Bramford to Twinstead Reinforcement

Document 8.3.2.2: Applicant's Written Summary of Oral Representations to Issue Specific Hearing 1

Final Issue A
September 2023

Planning Inspectorate Reference: EN020002

ELEVATION - B  
 SCALE 1:150

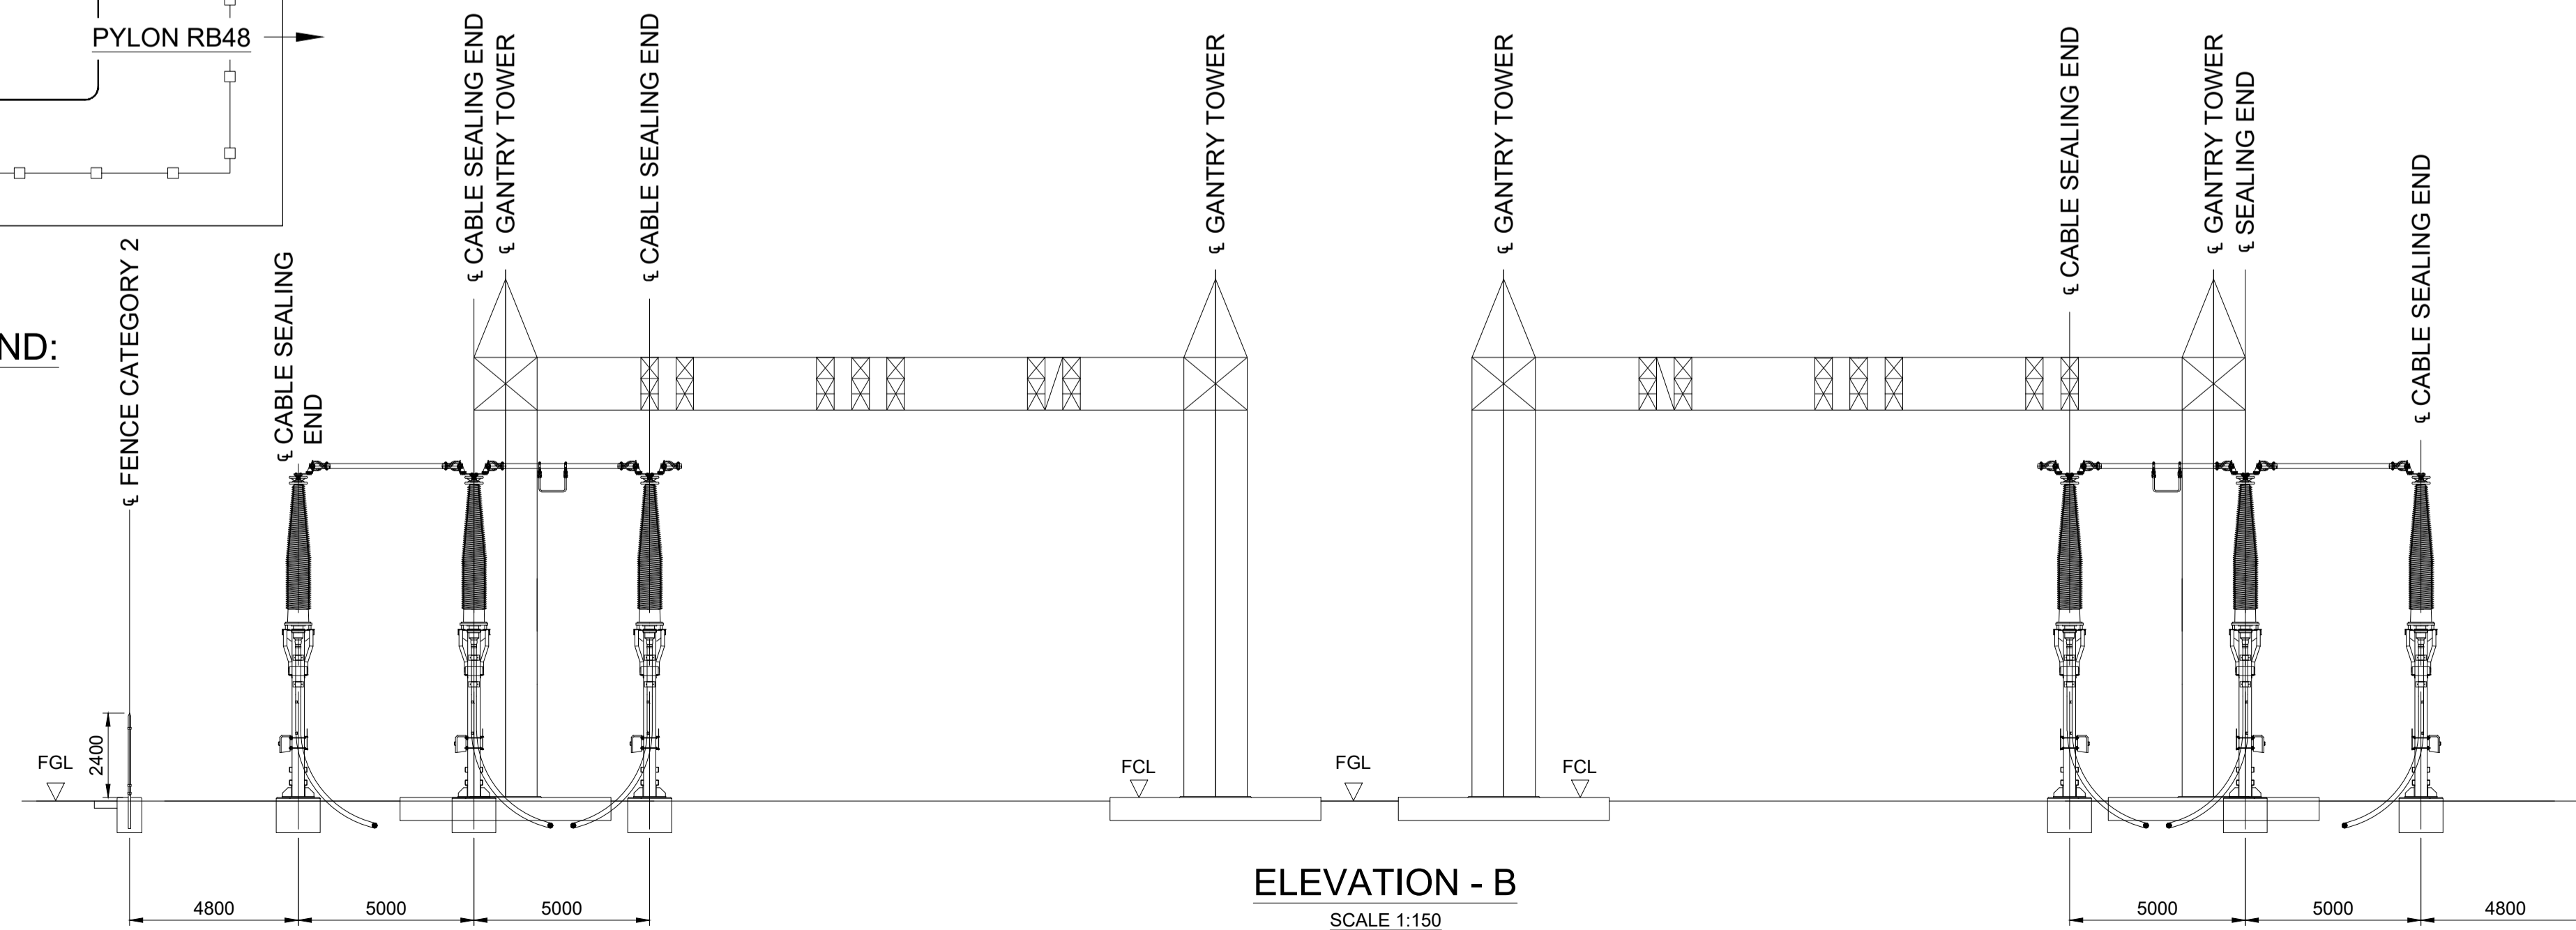
Stour Valley East CSE Compound

The equipment used within the CSE compound, as per Design and Layout Plans Stour Valley East Cable Sealing End Compound [APP-025], is in accordance with technical requirements and with other similar compounds utilised throughout the National Grid network. The size of the compound is circa 45m x 70m and is necessary to accommodate the required equipment and to provide a safe and secure compound throughout the asset life.

The LoD for the CSE compound are intended to allow the main works contractor, once appointed, some flexibility with the final positioning / layout of this compound. This assists with the detailed design of the compound and the interface positions between the underground cable and overhead line whilst at the same time constraining the position of the CSE compound within the area assessed.

The LoD have been derived by applying a 25m buffer zone on each side of the CSE compound dimensions, as per Design and Layout Plans Stour Valley East Cable Sealing End Compound [APP-025] which allows for the repositioning of the compound to suit final overhead line / underground cable alignments, or to relocate equipment items if needed to avoid unexpected ground conditions.

At the CSE Compounds the non-linear LoD and the linear LoD overlap to allow for all equipment to be accommodated within the LoD.
